This supplementary planning submission relates to the rebuttal of residents' objections, by the applicant and his design team on 25th November 2022. It should be read in conjunction with all our previous comments for this site. For clarity we re-iterate that:

Our main objection is still that the building design, layout and housing density conflict sharply with the rural fringe, Pennine hillside, location and will have an unacceptable adverse impact on the landscape and existing properties bordering the site.

Introduction. The main objections relate to density, use of 3 Storey dwellings, traffic, drainage and conflict with the rural fringe character. Other more technical matters covering drainage, land drainage, highways, retention of Lingards Road and ecology are being addressed by consultants Haigh Huddleston, Paragon and Middleton Bell in consultation with Kirklees Council for which revised details have been submitted. Where agreements can be made and conditions attached, I don't believe the developer will have objection.

Project HOUSING AT LINGARDS RD SLATWATE	
Client SB HOMES LTD	
Drawing SITE SECTIONS ACROSS LINGARDS RD	
Scale 1:200	Date 19.07.22
Dwg No 2019 572 61	Rev

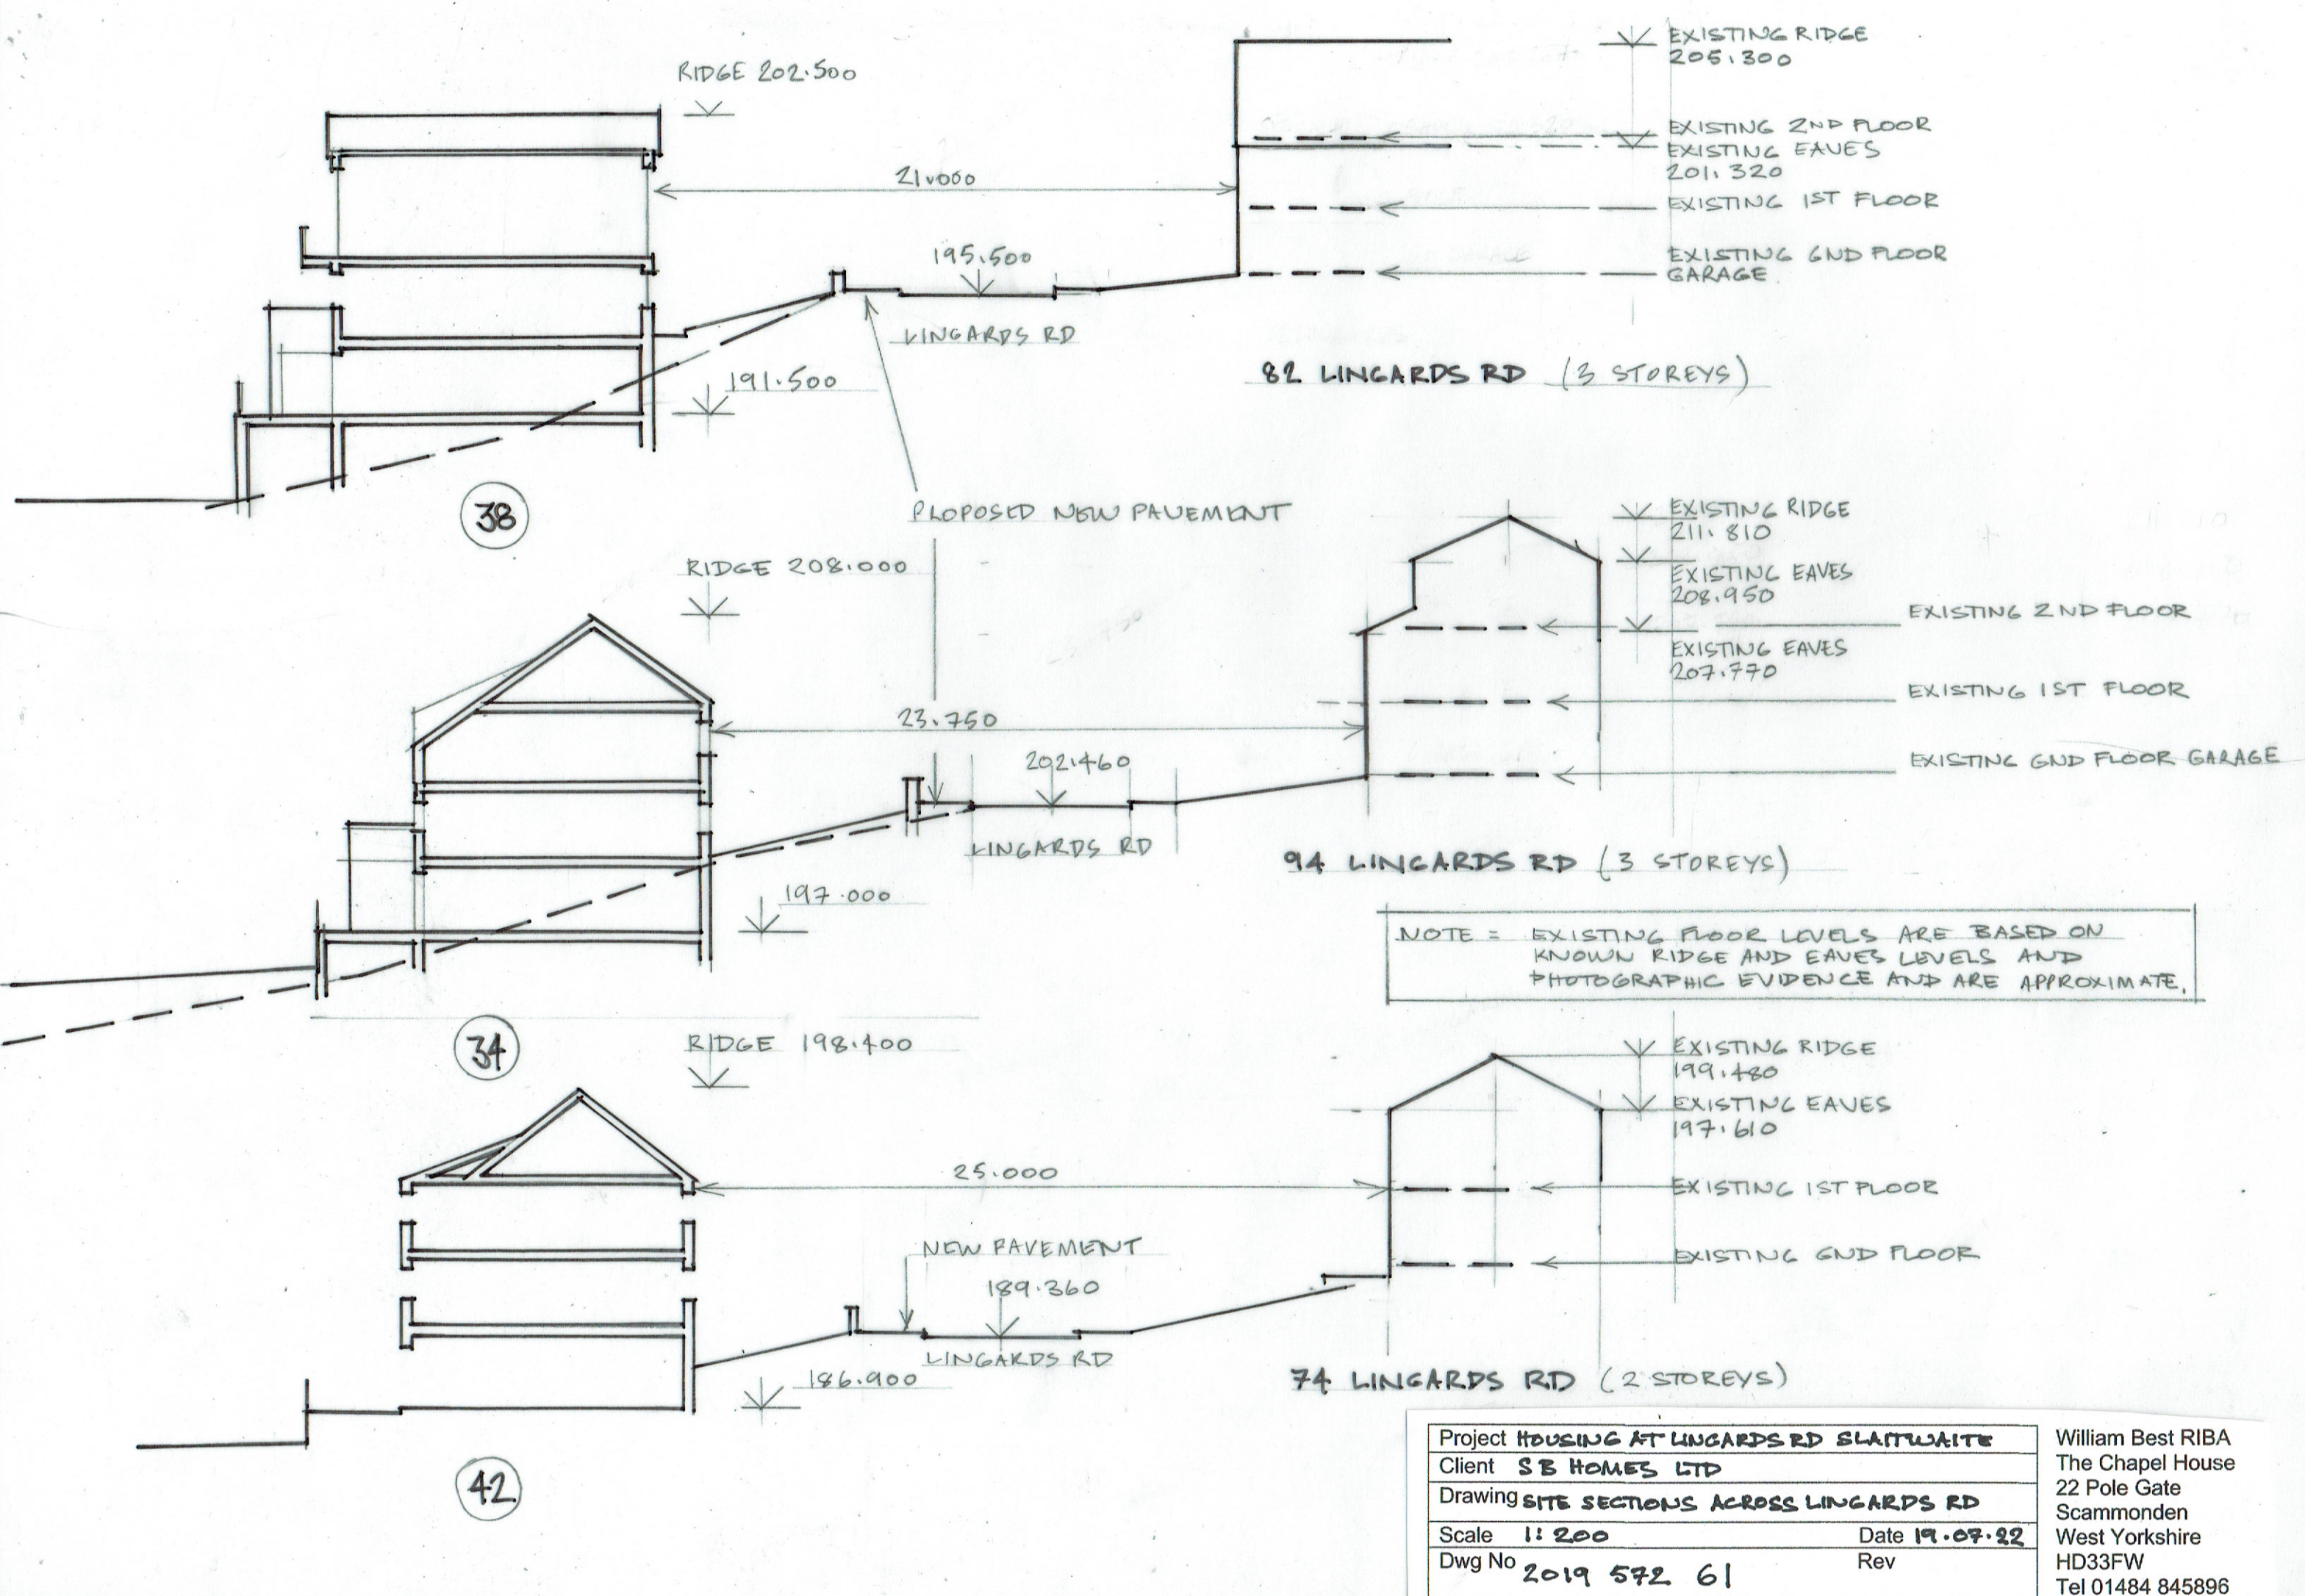
18. No True Site Sections! Refer to the extensive site section drawings included in the application.

No comment, although some details are conveniently missing from the site sections.
